Demolition of existing garage & store on existing dwelling & construction of 2 new dwellings in rear garden.

6 Manor Road Rustington

Thank you for your internet representation made on 24th July 2019 which has been recorded as '**an objection**' with the comments as follows:

DRAWING: PROPOSED NEW DWELLINGS - PLANS **SCALE:** 1:50 @ A2 **DATE:** 11/07/2019 **DRAWING No:** DS/6MANOR/04 rev 2

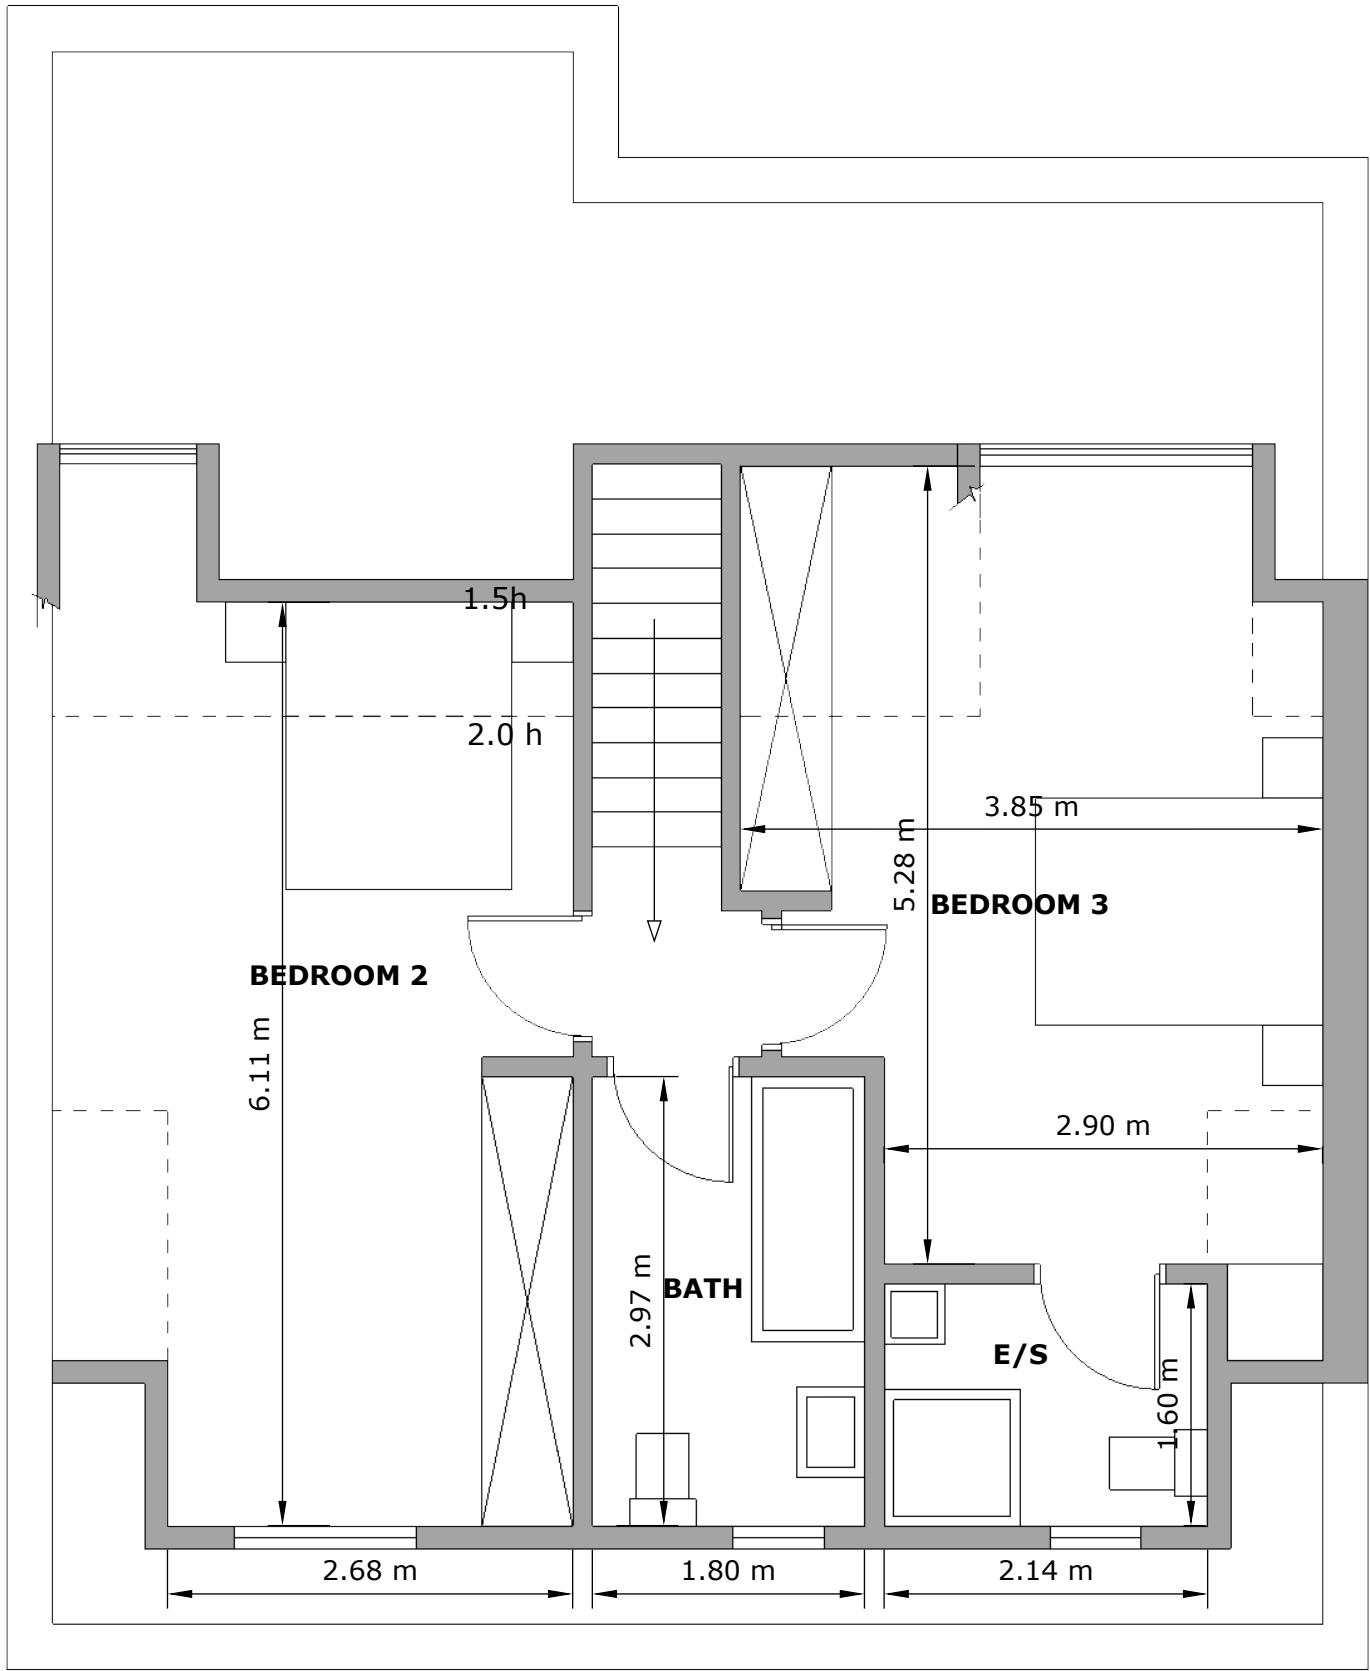
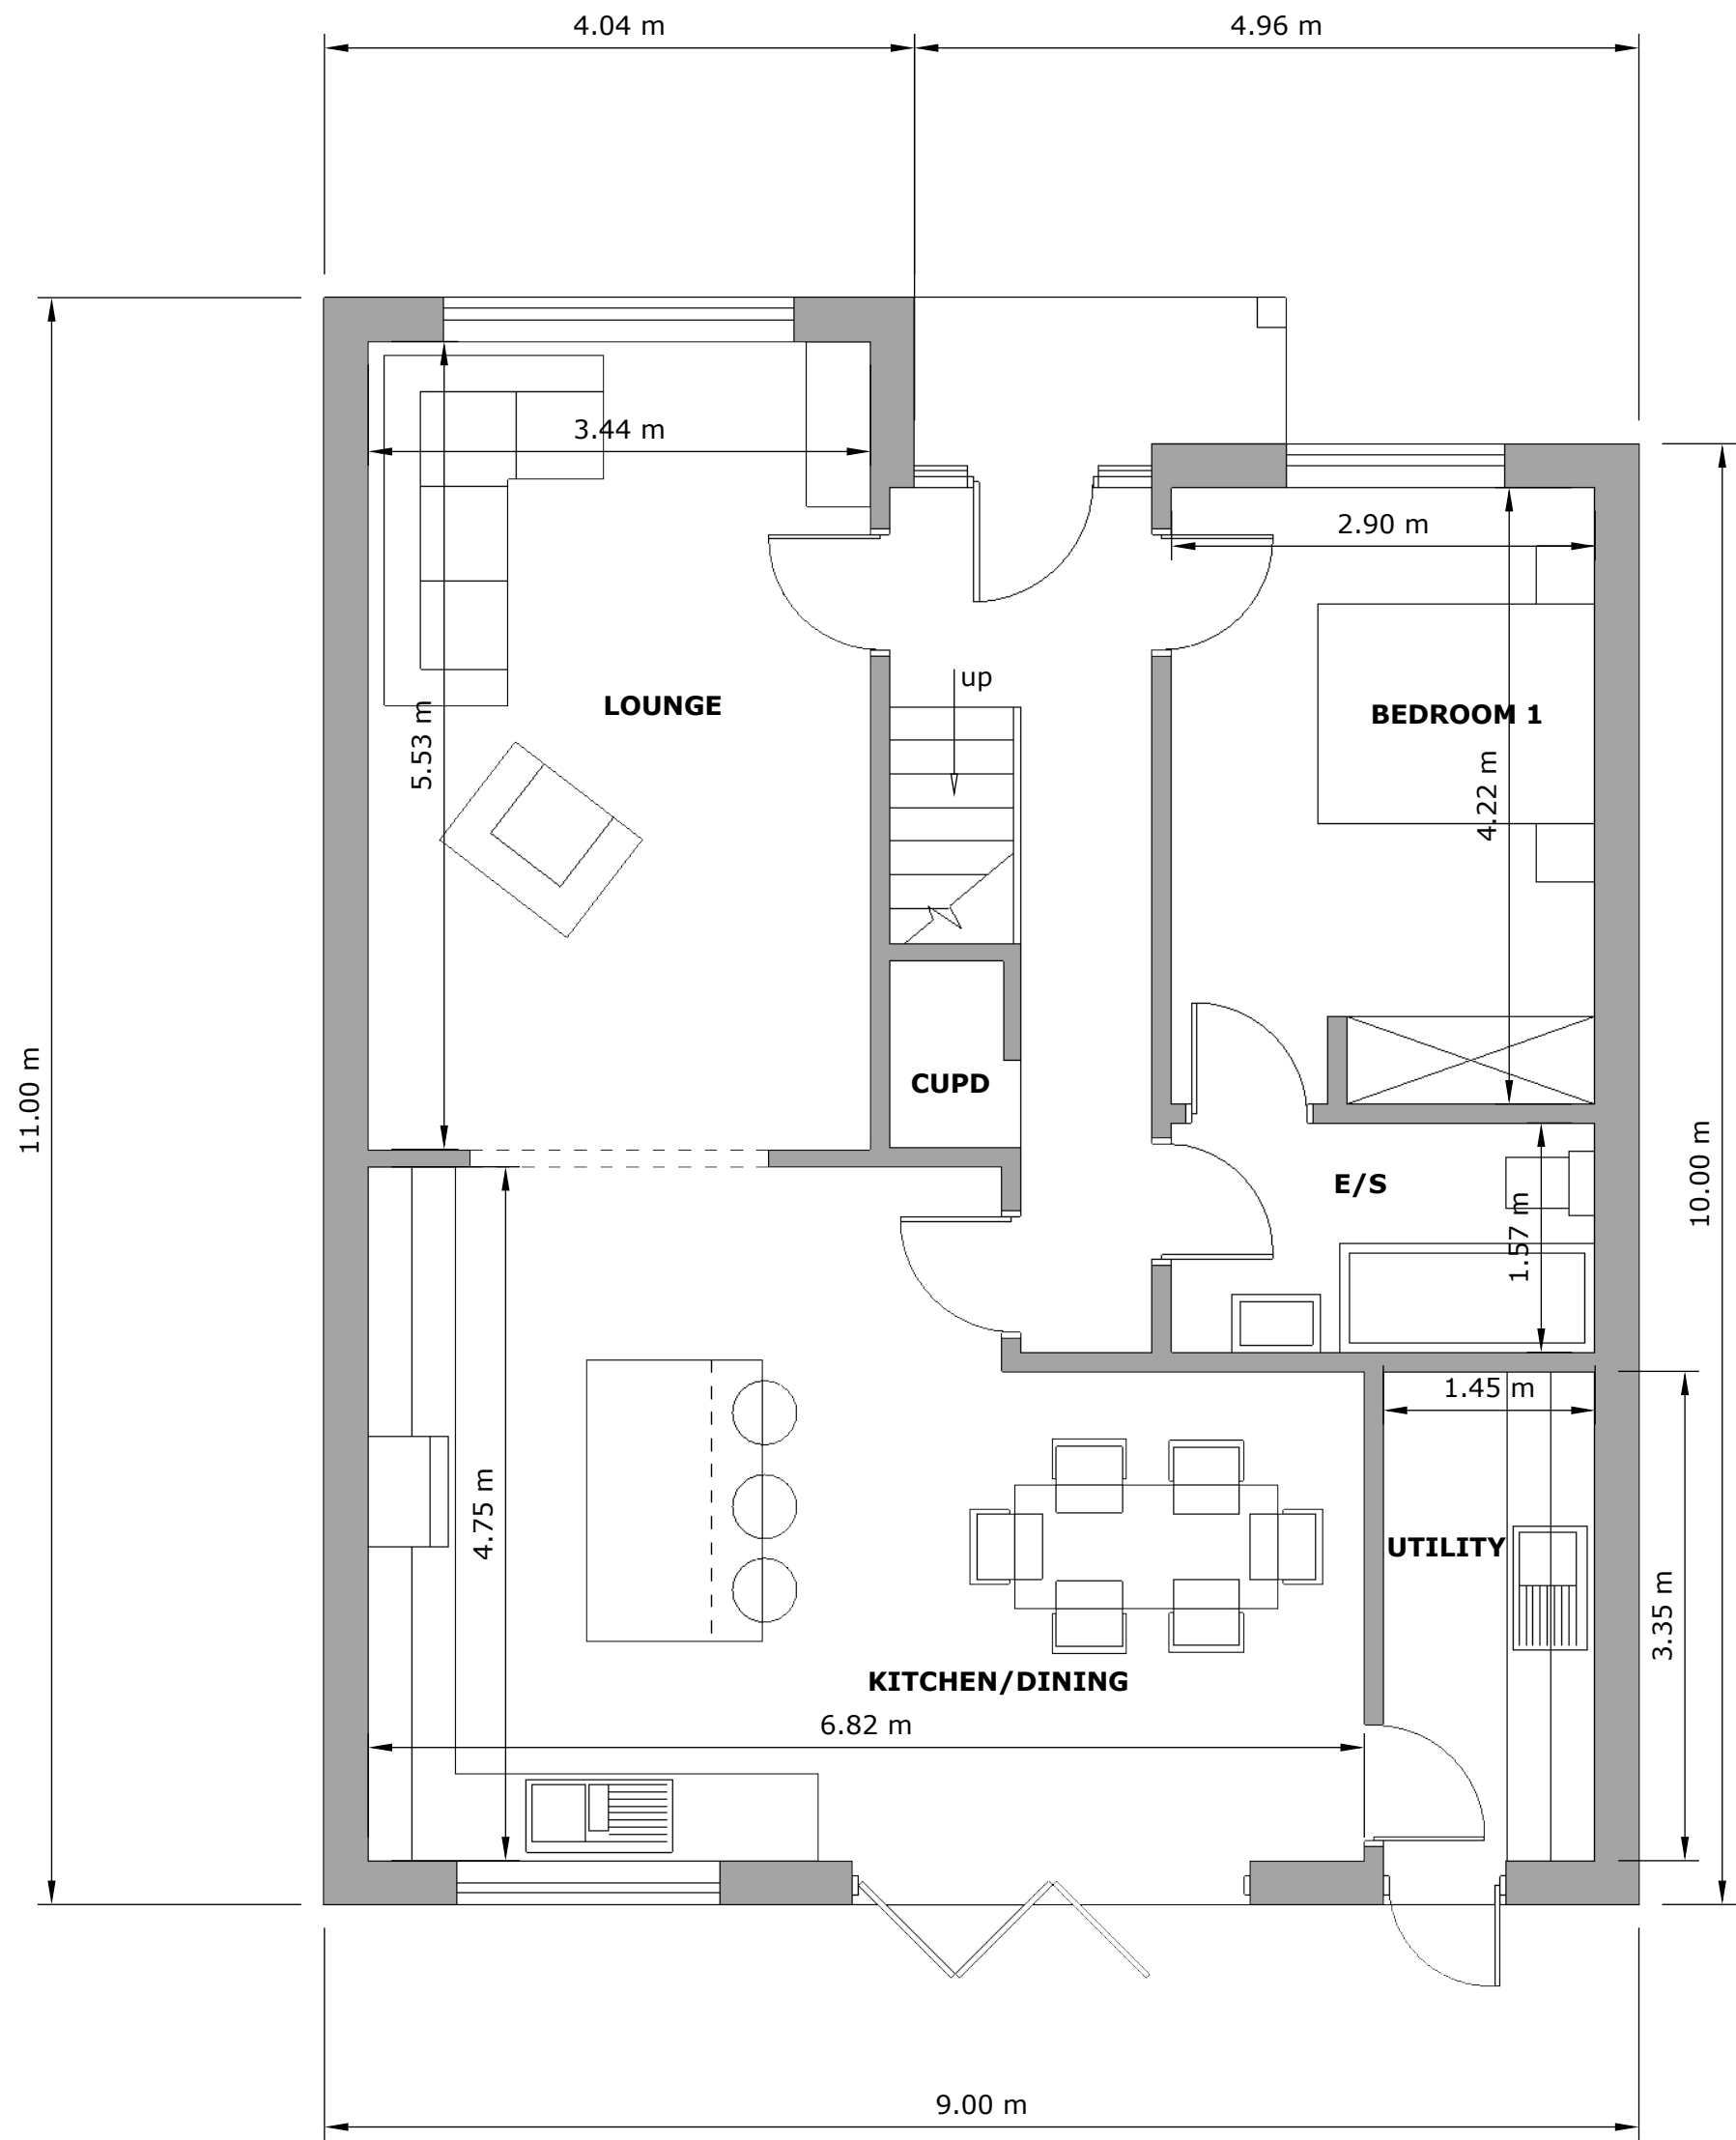
We have today reviewed the amended plans and would still like to object to the over development of 2 additional detached properties in the back garden of number 6 Manor Road. As far as I can see the only amendment to the existing drawings is that there is now a window in the dormers which looks directly into our private space within the garden and our own dwelling at number 1 Grafton Close which is totally unacceptable.

DRAWING No: DS/6MANOR/03 rev 4

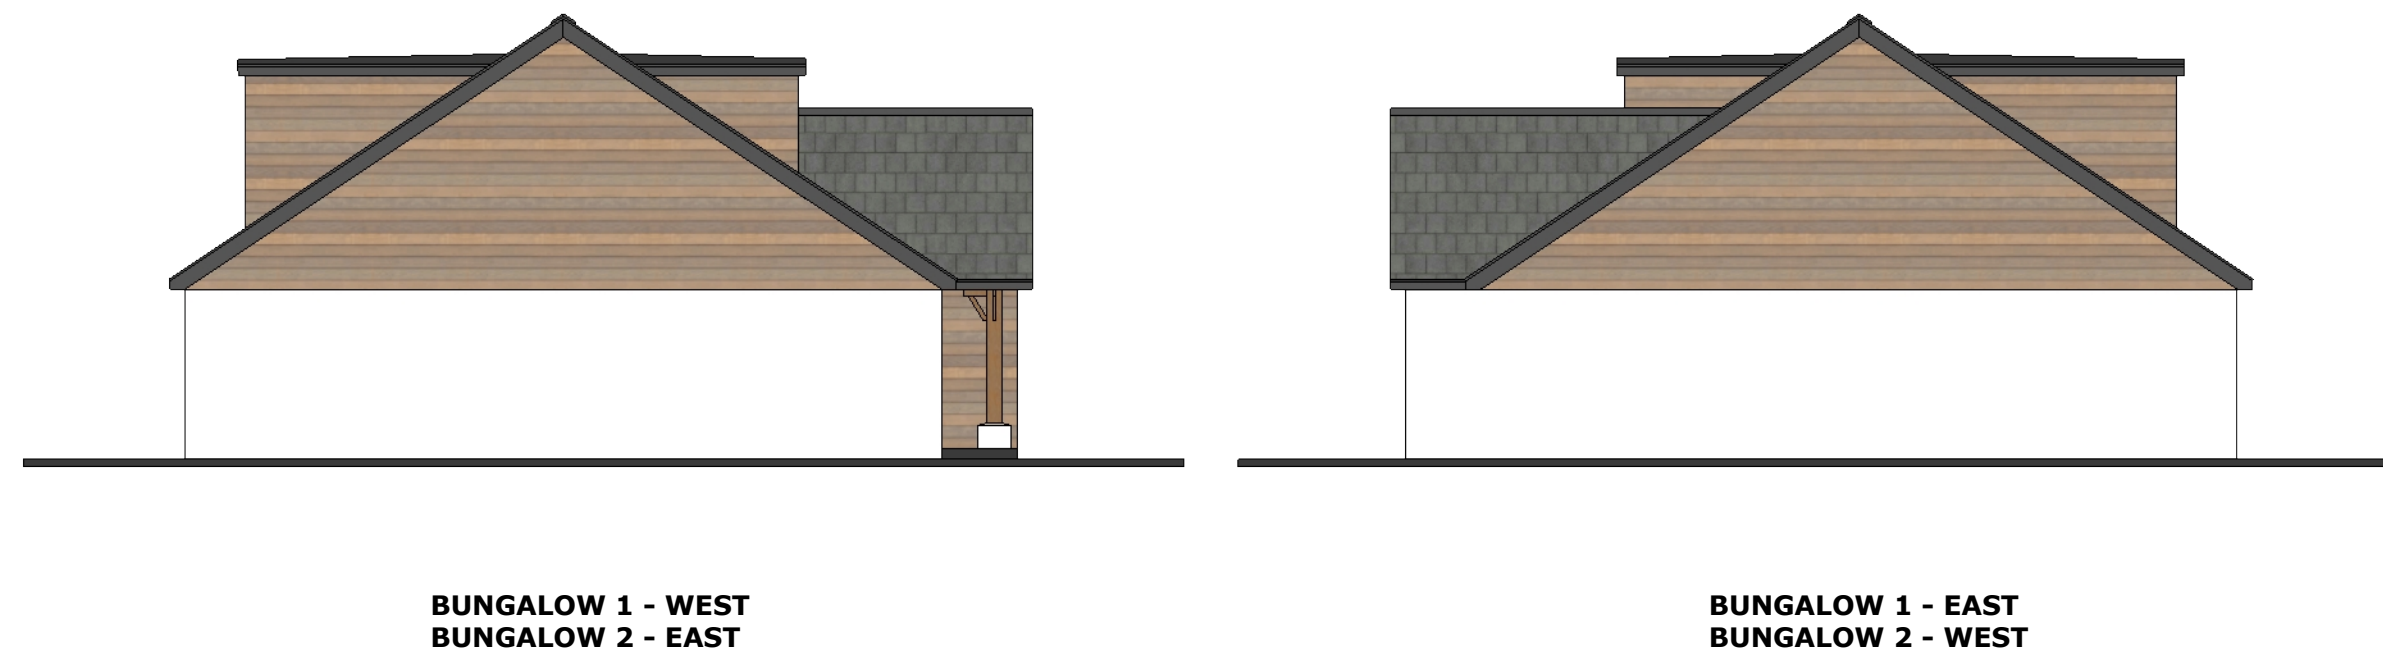
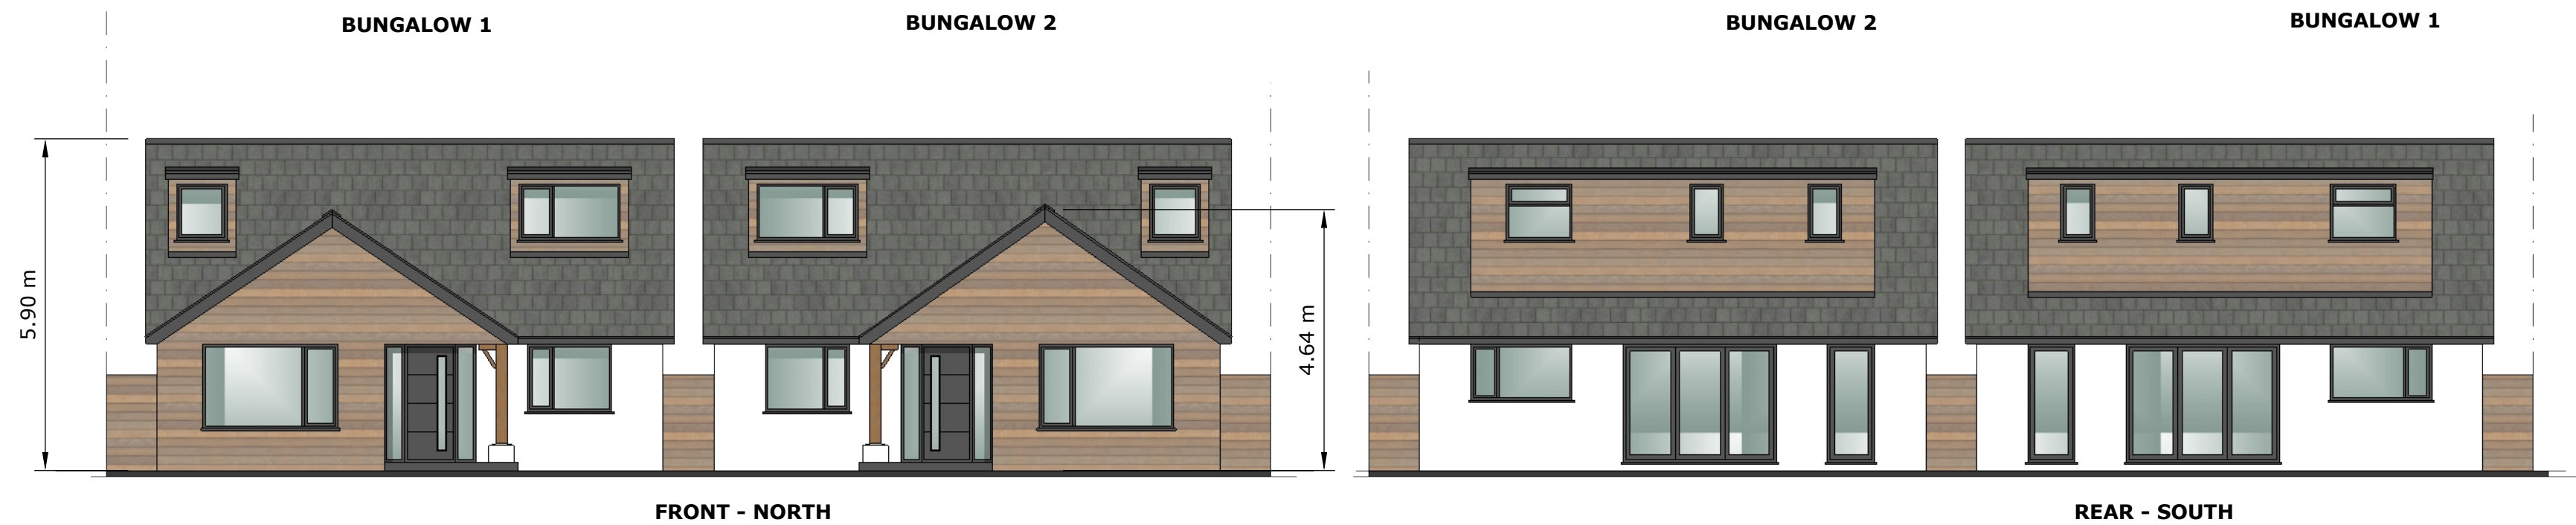
- *The ridge height of the new proposed dwellings are far higher than the existing ridge heights of numbers 2, 3 and 4 Grafton Close. Measured off the drawings to be nearly 1 metre, this is not in keeping with the proposed building line and existing properties*

- *There are now windows looking into our property as previously we have had none, our private space will be compromised*
- *Our concerns with the additional traffic and parking still remain the same especially around start and finish of school making this a dangerous area for children and their parents at these times*
